PLANNING CONSULTATION RESPONSE

Application No	2026/0657
Proposal	Erection of 1no. building for industrial (class E(g)(iii)/B2) or storage and distribution (class B8) use with associated yard, parking, landform and landscaping (Reserved matters of the outline part of hybrid planning permission 2019/1573) for Unit 6 seeking approval of access, appearance, landscaping, layout and scale.
Address	Land to the north and south of Dearne Valley Parkway, Hoyland, Barnsley
Date of Consultation Reply	02/10/26
Consultee	Nik King, Senior Urban Design Officer

These are the design comments for planning application 2026/0657.

## Boundary Treatments

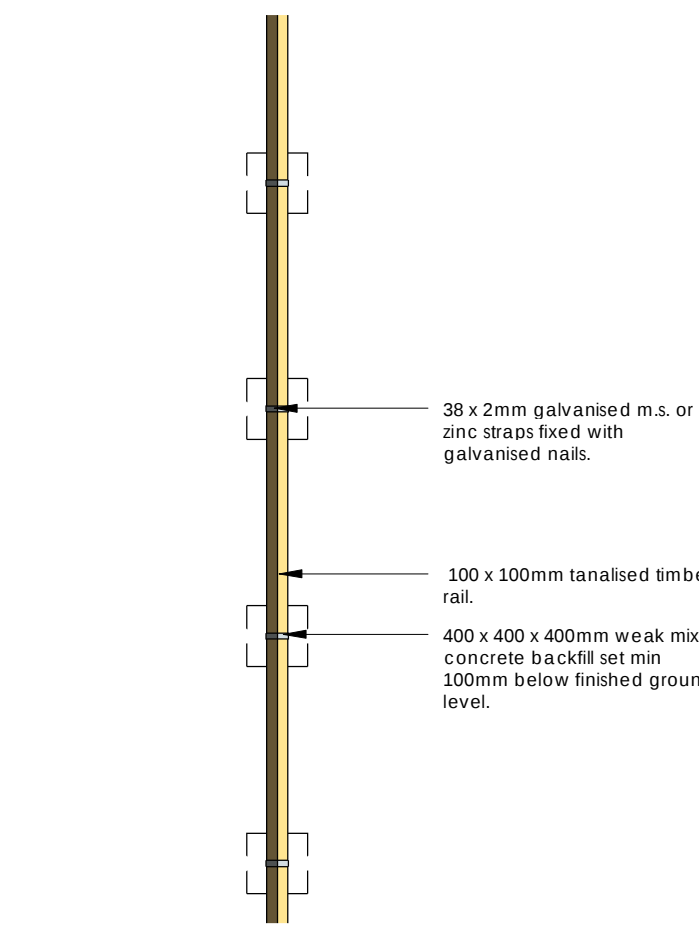
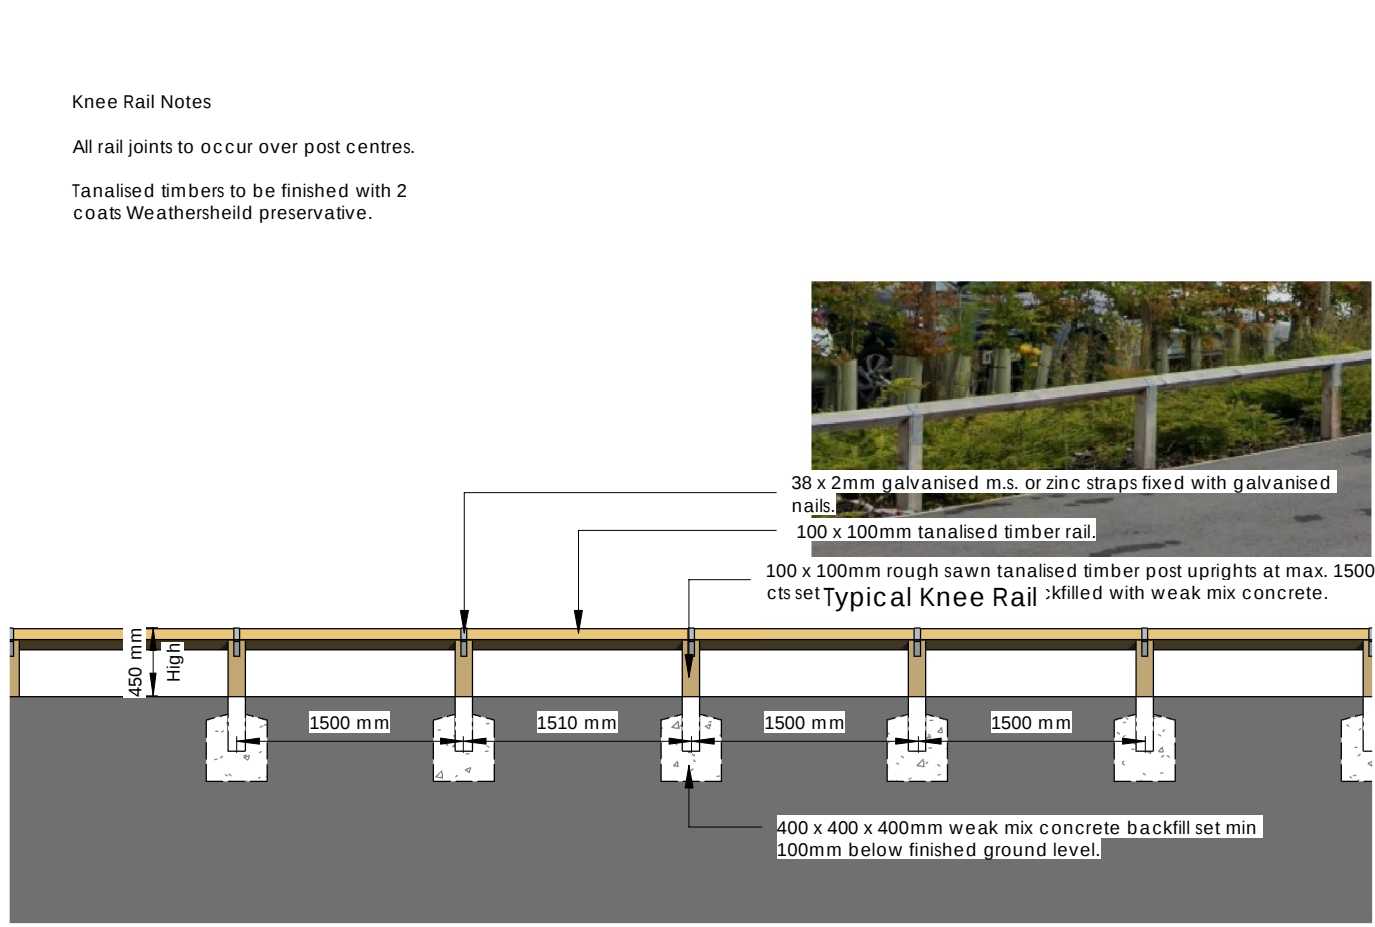
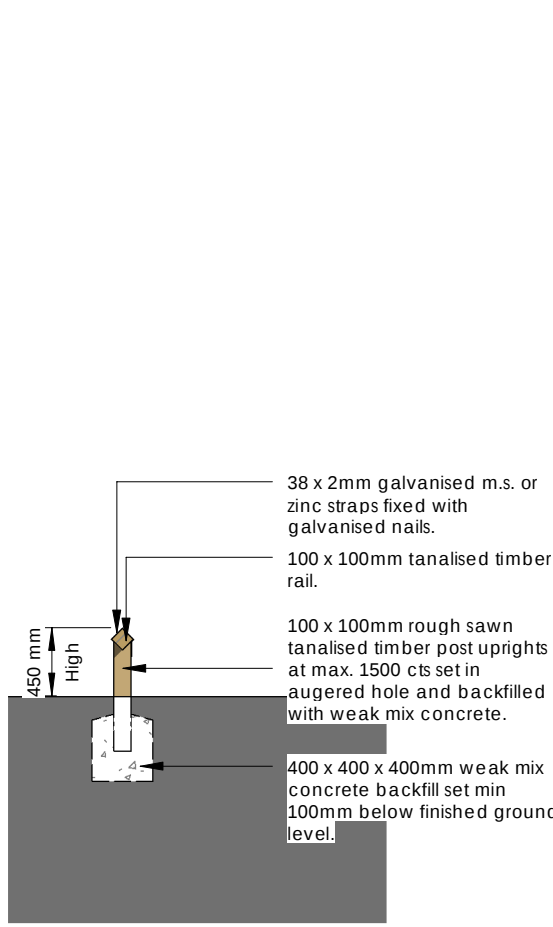
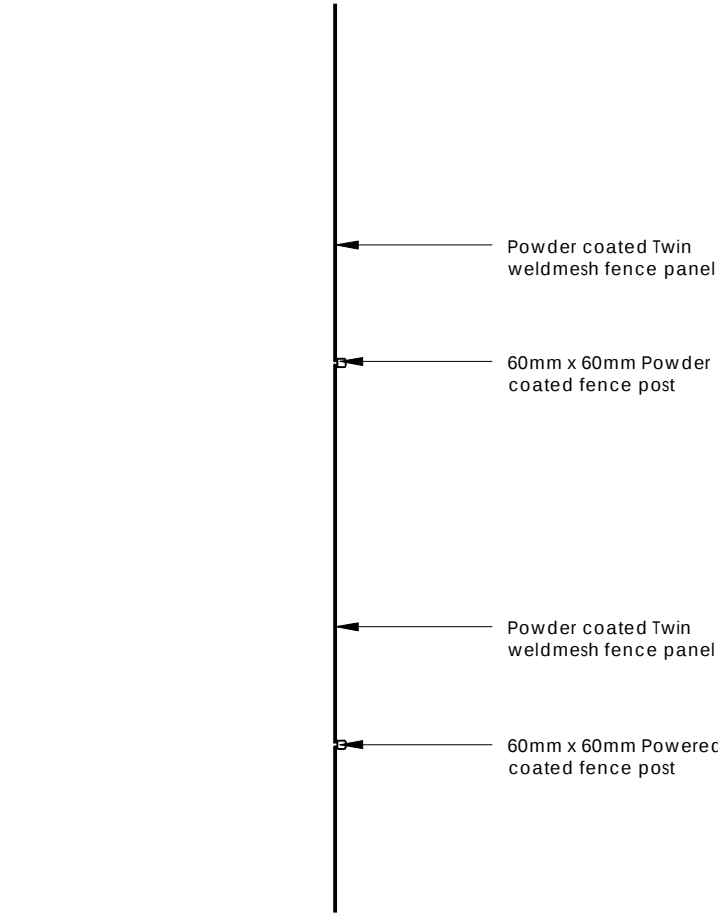
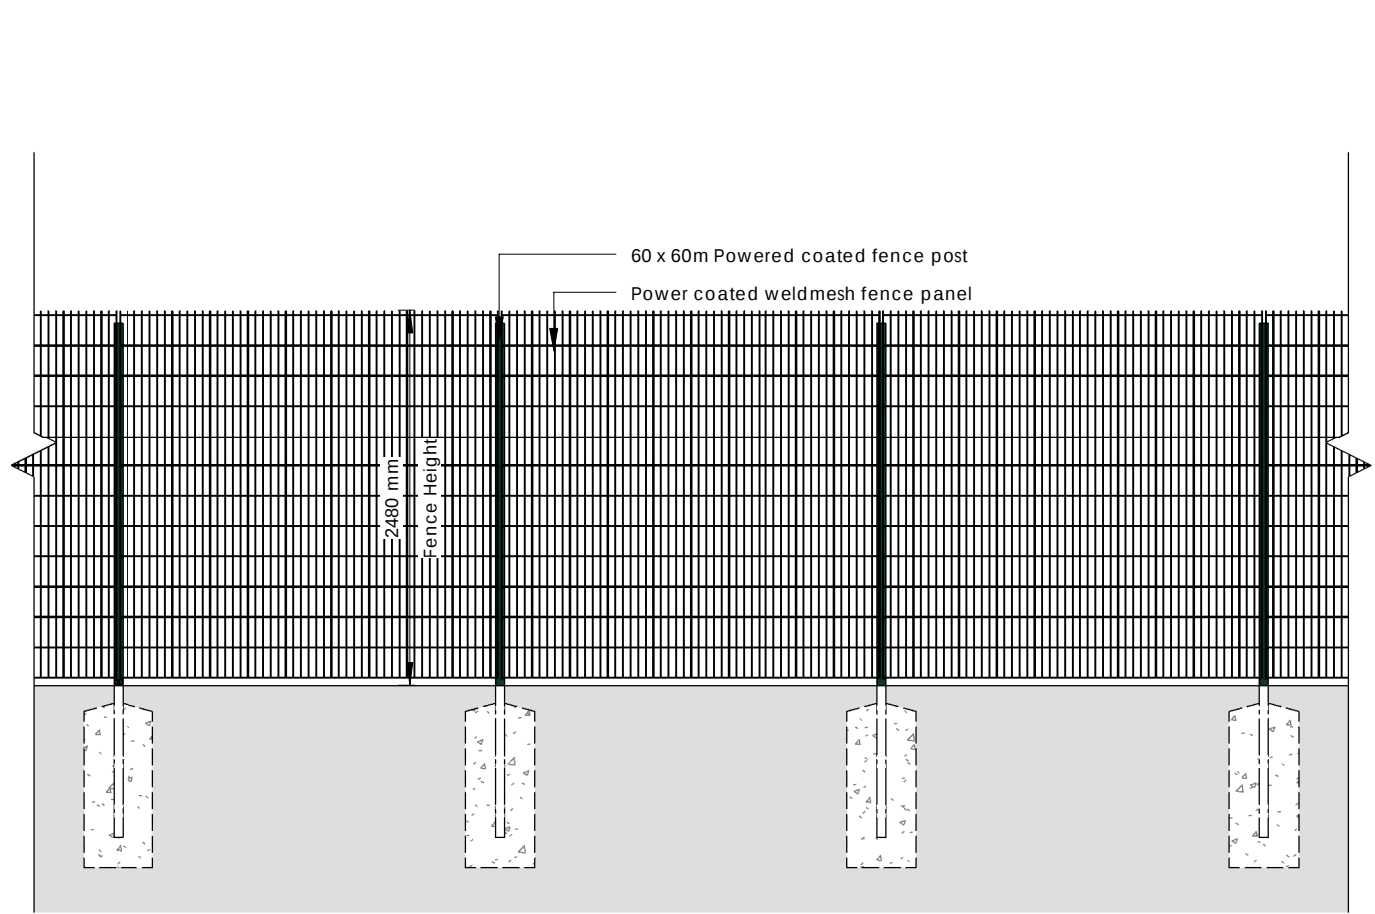
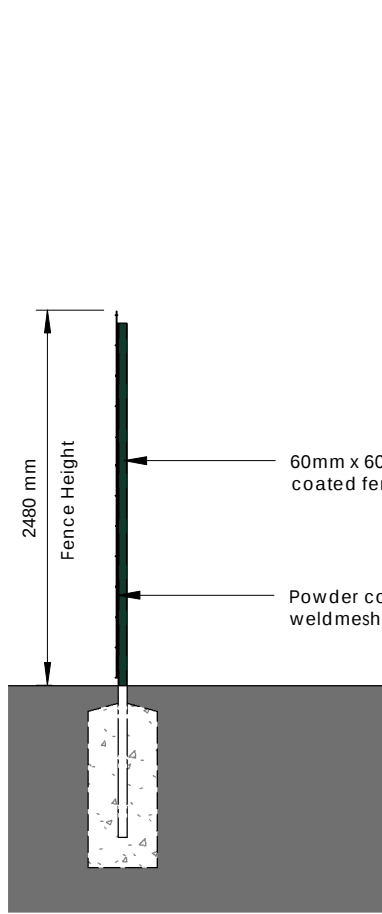
From the drawings 'Boundary Treatments/ Materials Plan', (Rev P04), 'Boundary Treatments' (Rev P03), 'Landscape Masterplan Unit 6' (Rev P) and 'Proposed Landscape Plan' (Rev PO4), I note that on the boundary of the site with the service yard is a 2.4m high twin weld paladin fence (in moss green), a mixed species native hedge planting which, once established, will be maintained at 1.5m high, and some native trees. I note that the distribution of native trees is very sporadic along the length of the hedge, with lots of long gaps. I am *assuming* that these trees are on the platform itself and not on the slope, (there is no detailed cross section that shows this). I am assuming that the trees and hedge will be deciduous, so will provide less cover of the lighting during the winter months, when the days are darker and the service yard and car park will be lit for longer.

From the same drawings, I note that the north-western boundary of the separate car park has no fence, hedge and minimal trees- the car park practically goes to the edge of the platform/ site boundary.

Unit 6 Elevations

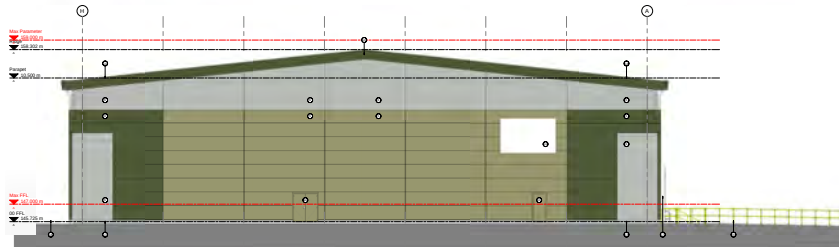
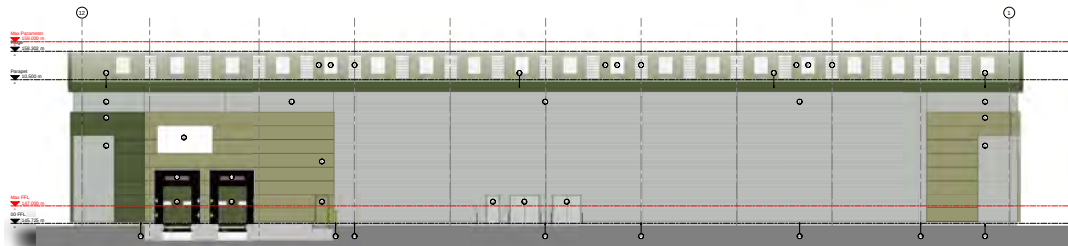
For any elevations that are on the south-western edge of the platform of the Gateway 36 phase 2/3 sites, please can these be more green than grey in colour, (in a similar way that the elevations on the north-western edge are). These 'edge' elevations are the most exposed to public views, including long-range views, so I would like them to be more based on the colours of the natural landscape. I appreciate that on the drawing 'proposed elevations' (Rev

PO4), the 'service yard elevation (south west)' is a long elevation, and there is an intention to help break down the massing and scale of the building through the use of colour, but as currently proposed this elevation is much more grey than green.

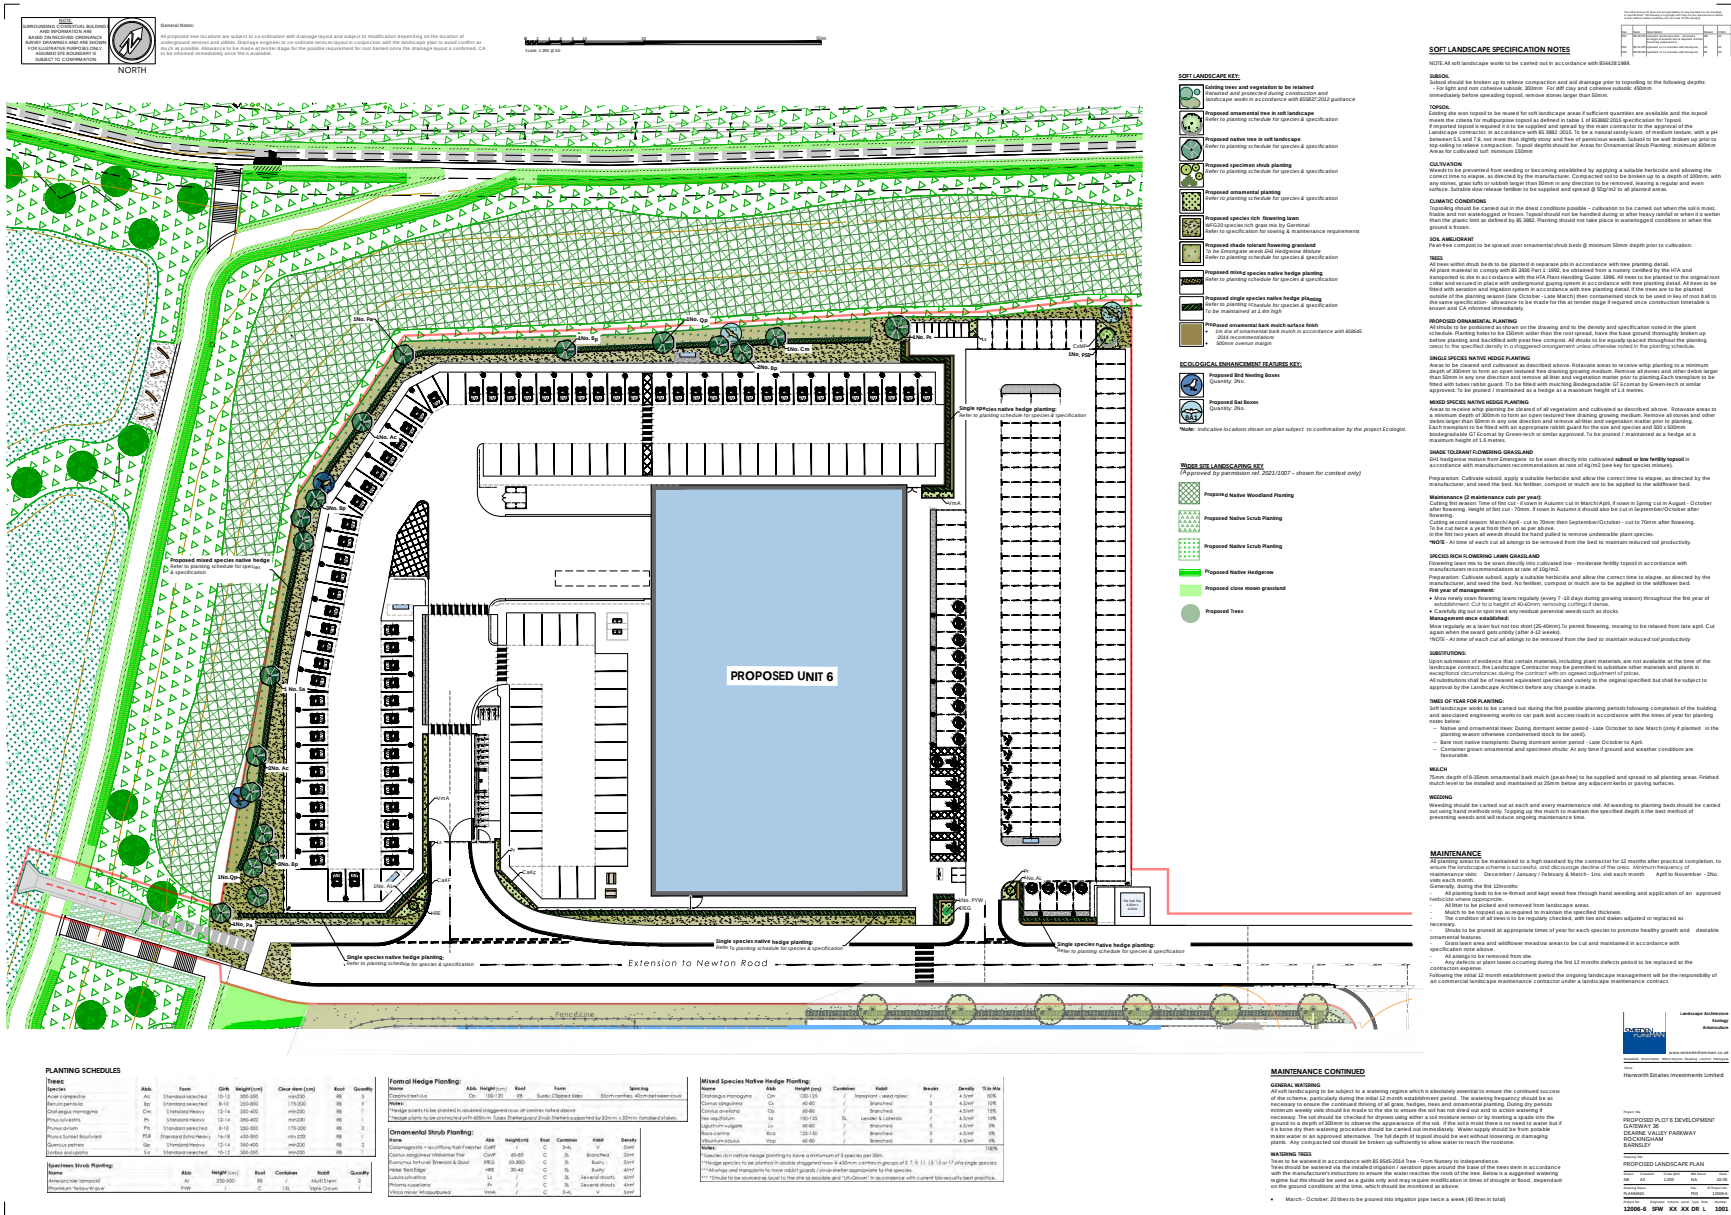
I note that the cover of the design and access statement clearly shows trees being planted by the side of the building, (as shown below), facing the access road. However, these trees are missing on the landscaping drawings.
